Engineers Comments Regarding Surface Water Drainage

Application No: WA/48/22/HH
Registered: 17th May 2022
Site Address: Kelsey Eastergate Lane Walberton BN18 0BA
Grid Reference: 496506 106074

Description of Works: Installation of a front entrance porch and covered way, single storey rear extension, two storey pitch roof side extension, conversion of roofspace to habitable use with gable end roof, detached carport and a detached summer house to rear.

Title
Plans as Proposed

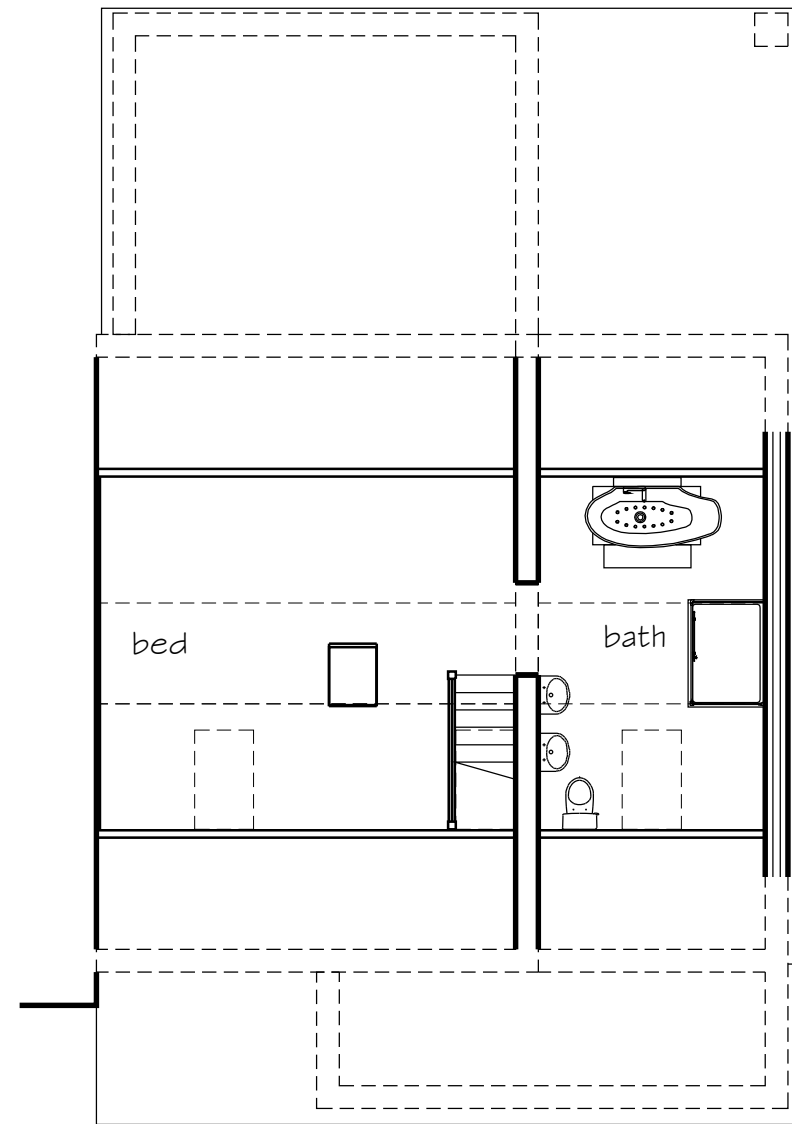
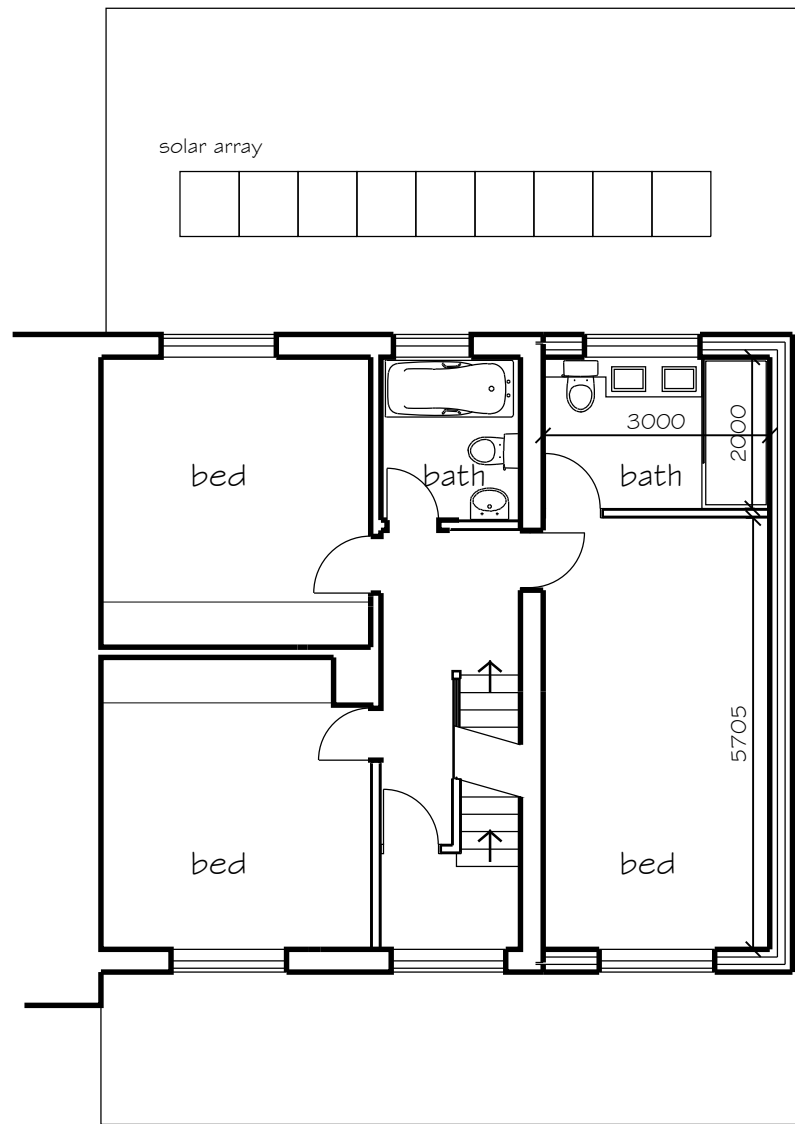
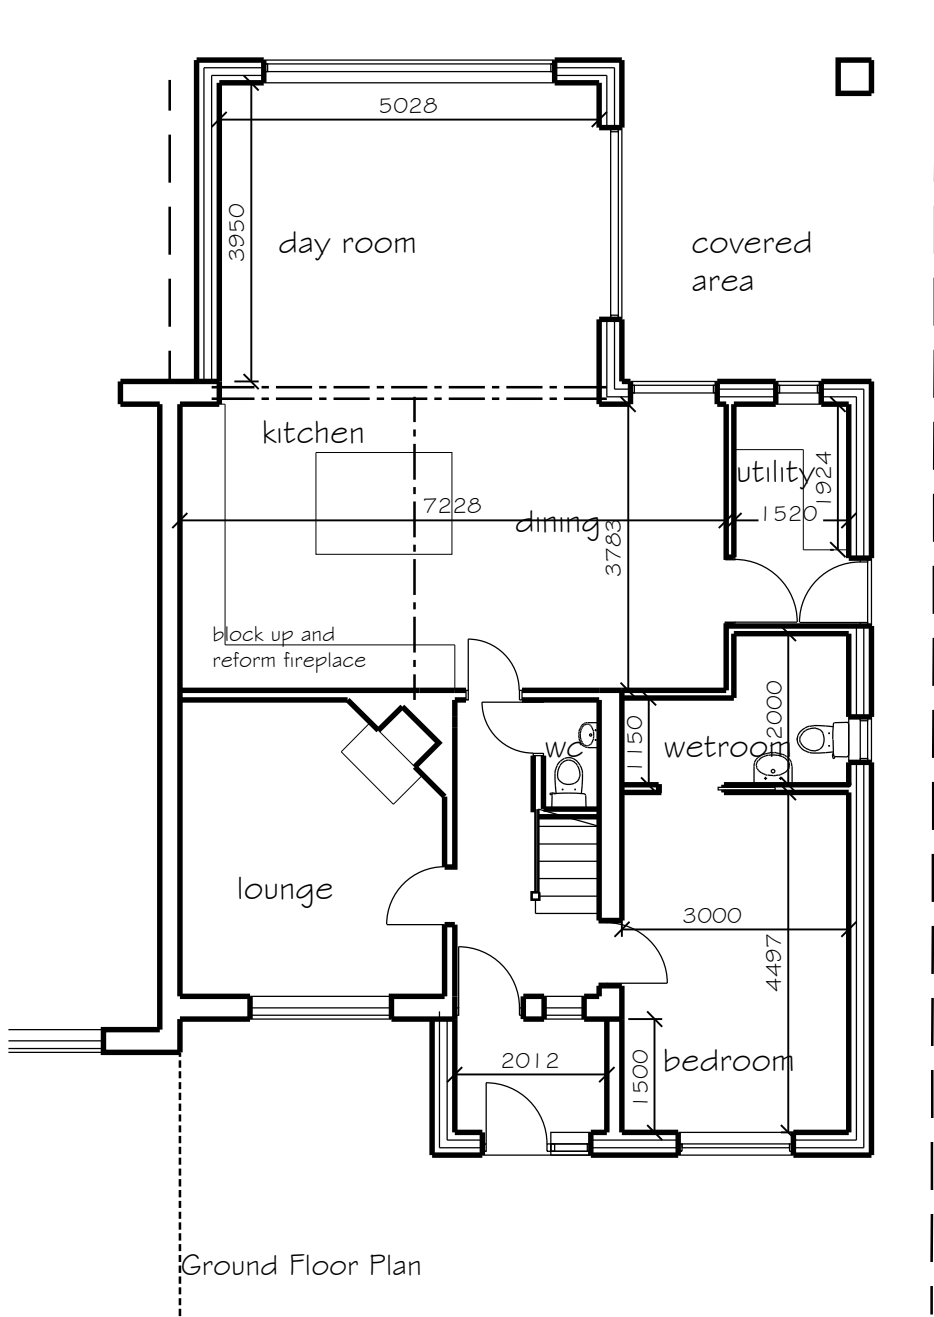
The application is within the Lidsey Treatment Catchment, therefore surface water drainage design should be carefully considered. Infiltration must be fully investigated. All new proposed impermeable areas must be accounted for in the drainage design, a net increase due to the existing conservatory is not appropriate as this is unlikely to have been installed with surface water drainage to meet our requirements.

“Development shall not commence, other than works of site survey and investigation, until full details of the proposed surface water drainage scheme have been submitted to and approved in writing by the Local Planning Authority. The design should follow the hierarchy of preference for different types of surface water drainage disposal systems as set out in Approved Document H of the Building Regulations, and the recommendations of the SuDS Manual produced by CIRIA. Winter groundwater monitoring to establish highest annual ground water levels and winter percolation testing to BRE 365, or similar approved, will be required to support the design of any infiltration drainage. No building / No part of the extended building shall be occupied until the complete surface water drainage system serving the property has been implemented in accordance with the agreed details and the details so agreed shall be maintained in good working order in perpetuity.”

“Infiltration rates for soakage structures are to be based on percolation tests undertaken in the winter period and at the location and depth of the proposed structures. The infiltration tests must be carried out in accordance with BRE365, CIRIA R156 or a similar approved method. All design storms must include a climate change allowance, as per <https://www.gov.uk/guidance/flood-risk-assessments-climate-change-allowances>, on stored volumes or rainfall intensity. Infiltration structures must cater for the critical 1 in 10 year storm event, (plus 40%) between the invert of the entry pipe to the soakaway and the base of the structure. All surface water drainage designs must also have provision to ensure there is capacity in the system to contain the critical 1 in 100 year storm event (plus 45%).

Adequate freeboard must be provided between the base of the soakaway structure and the highest recorded annual groundwater level identified in that location. Any SuDS or soakaway design must include adequate groundwater monitoring data to determine the highest groundwater table in support of the design. The applicant is advised to discuss the extend of ground water monitoring with the council's engineers.
